Subject: Marulan South Limestone Mine - Noise Management Plan

I refer to your submission dated 05 August 2022, requesting approval of the Noise Management Plan (Revision 1, dated 23 March 2022).

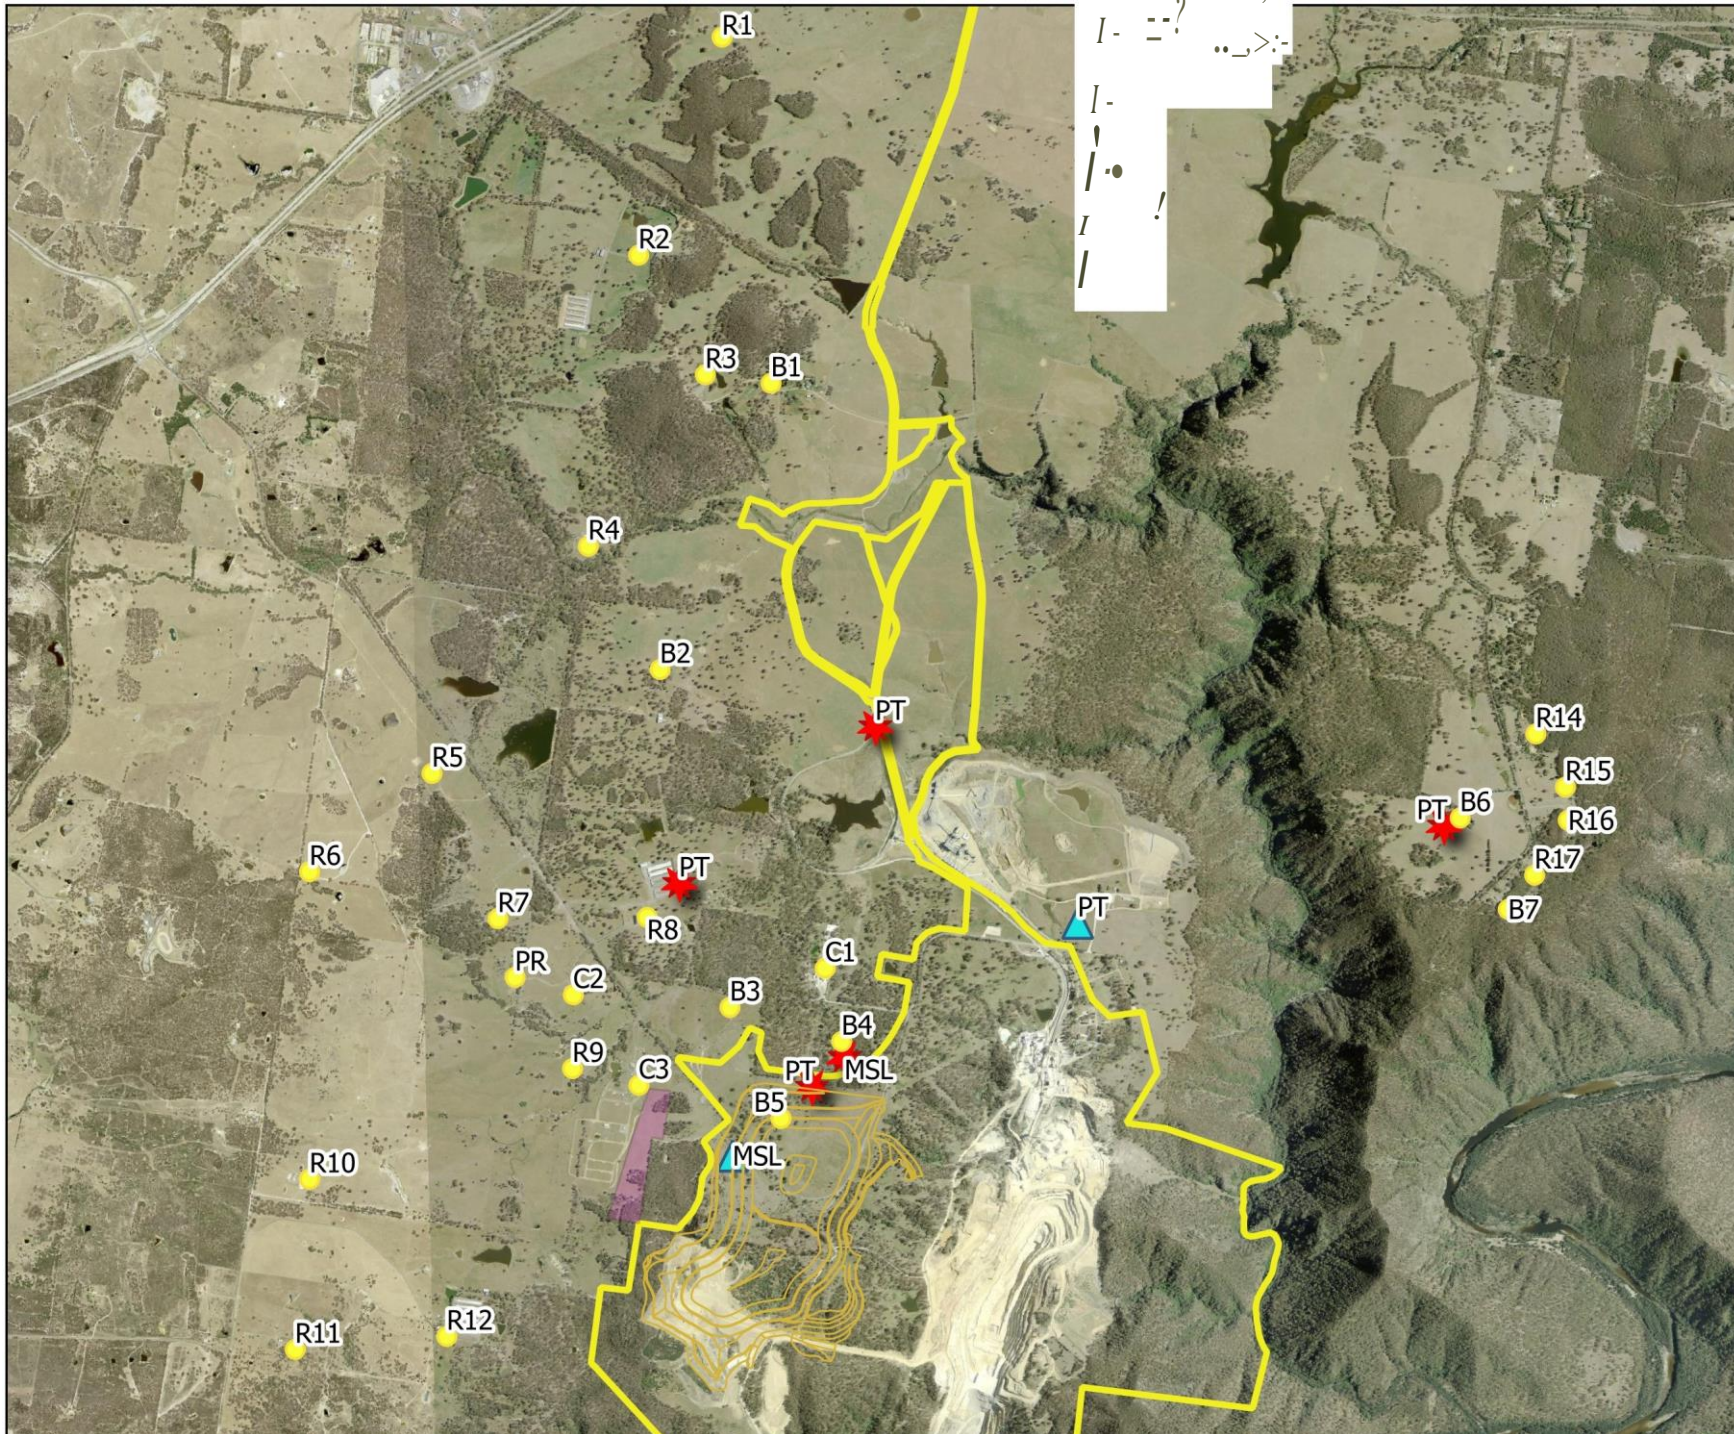
- the information provided on page 2 of Boral's RFI response detailing the existing noise attenuation measures currently implemented on all plant and equipment; and
- an explanation of why the NMT location is represented by a shaded area and not a specific point in figure 5.1 of the management plan.
